**Your Ref:** OWPC1834  
**Our Ref:** EP/143/13/ 03-12-2013  
**Please ask for:**  
Mr D Sullivan

Provision of new vehicular access and driveway to eastern boundary of property  
Middle Barn The Street East Preston

Thank you for your internet representation made on 15th January 2014 which has been recorded as '**an objection**' with the comments as follows:

PROPOSED ELEVATIONS 1:100

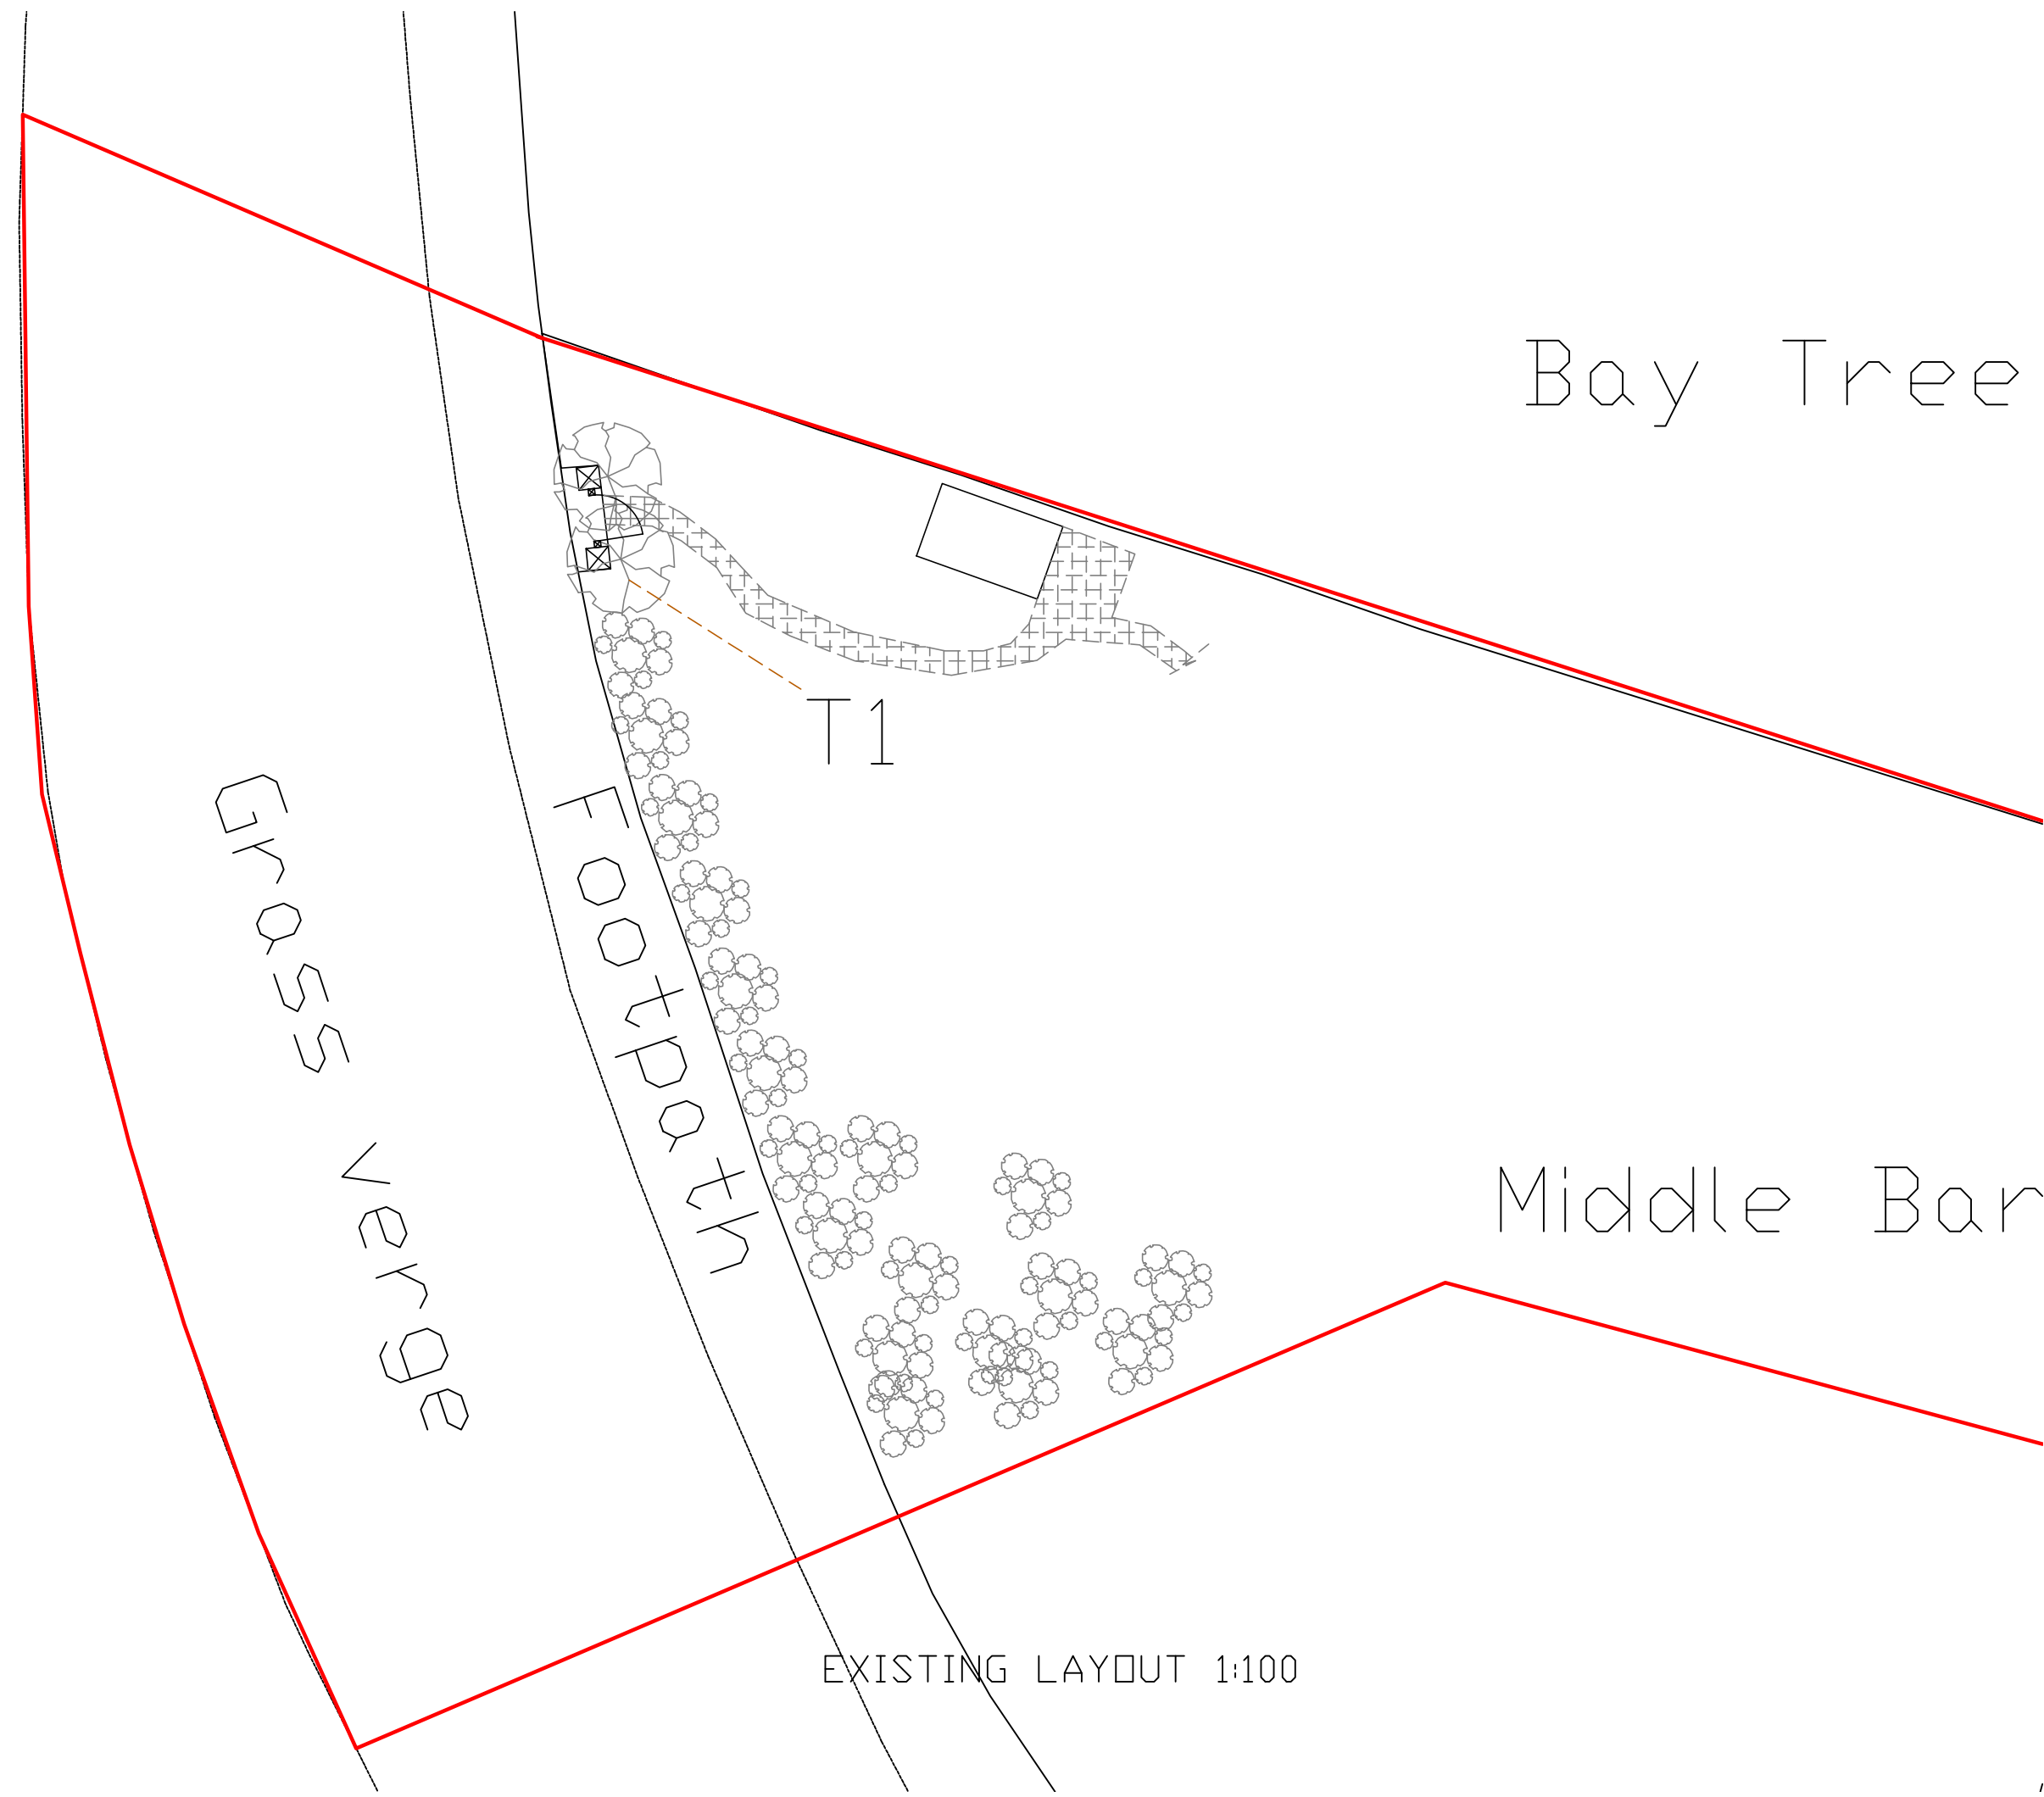
*The Society considers that the proposed new entrance would cause unacceptable harm to the appearance of The Street and to the setting of Middle Barn, a Building of Character. The new entrance would require a large break in the flint wall that now marks the boundary of the gardens of the three barns. This wall is an attractive feature of the street scene, and is now continuous around the bend of The Street. Creating a new vehicle entrance in the wall would significantly harm the appearance of this section of The Street. It would also harm the appearance of the setting of Middle Barn. The construction of a driveway across the verge, which is very wide at this point, would damage the appearance of this attractive sweep of grass.*

*The application is contrary to:  
Policy Dev19, because of its effect on the pattern of the street;  
East Preston Village Design Statement, because of its damage to a flint wall and a grass verge, both of which the VDS says should be preserved in this part of the parish;  
the National Planning Policy Framework (para. 129), because it affects the setting of a Heritage Asset.*
